Application No.	2020/94345
Proposed Development:	Erection of 5 dwellings
Location:	Land at, St Luke's, Bierley Marsh, East Bierley, BD4 6PL
OS Map Reference	SE 419864.6118 429222.552
Applicant/Agent:	nj-ARCHITECTS
Class:	Minor Developments

**Consultation Response from KC,
Highways Development Management**
2020/94345 Land at, St Luke's, Bierley Marsh, East Bierley, BD4 6PL
Erection of 5 dwellings
**Date
Responded: 19/03/2021**
**Responding Officer: Mark
Berry**
Responding Ref: 8-8SE-10

Drawing No. **H20017 - 220** Rev. **P2**

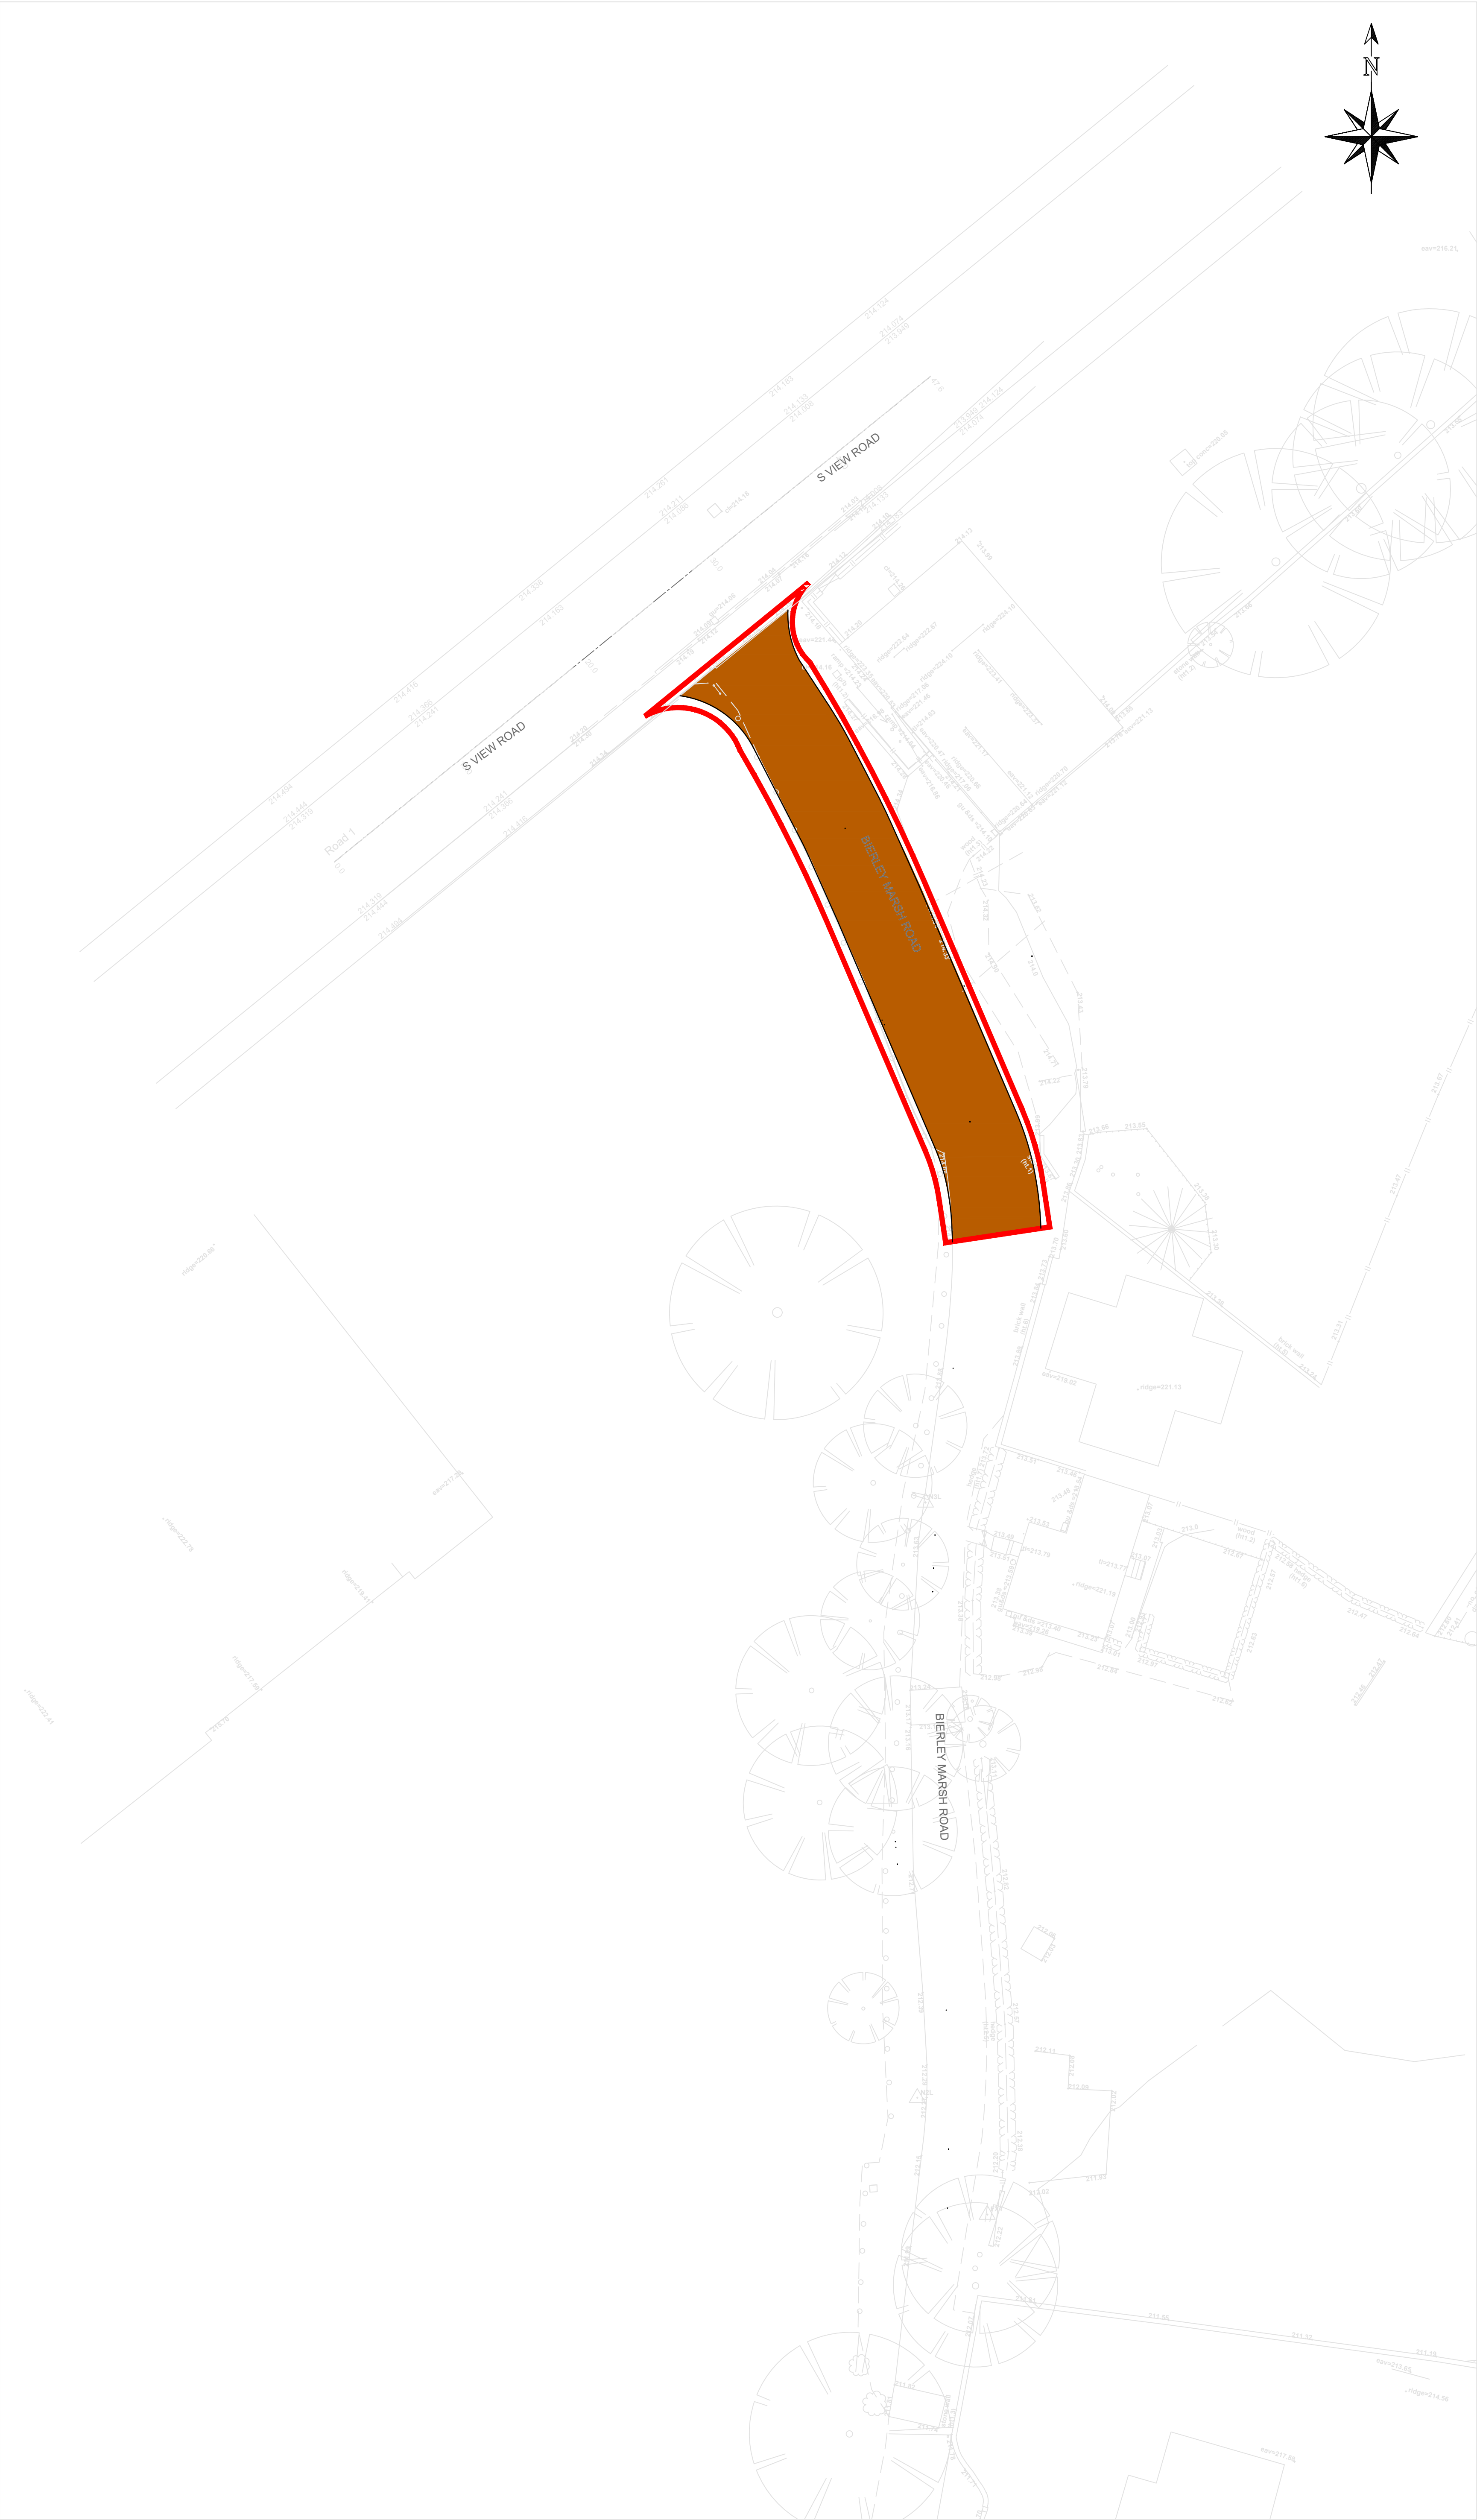
Kirklees Highway Design Guide recommends that new development serving more than 5 dwellings (or any existing private road which will serve more than 5 dwellings after completion of new development) should be laid out to an adoptable standard. The applicants have submitted indicative proposals to improve the section of Bierley Marsh road between the site and South View Road to adoptable standards.

Highways Development Management (HDM) have requested the advice of the section 38 road adoption team regarding the proposals to make-up part of Bierley Marsh road to adoptable standards and the possibility of its formal adoption as highway maintainable at public expense. These comments will be forwarded as soon as possible,
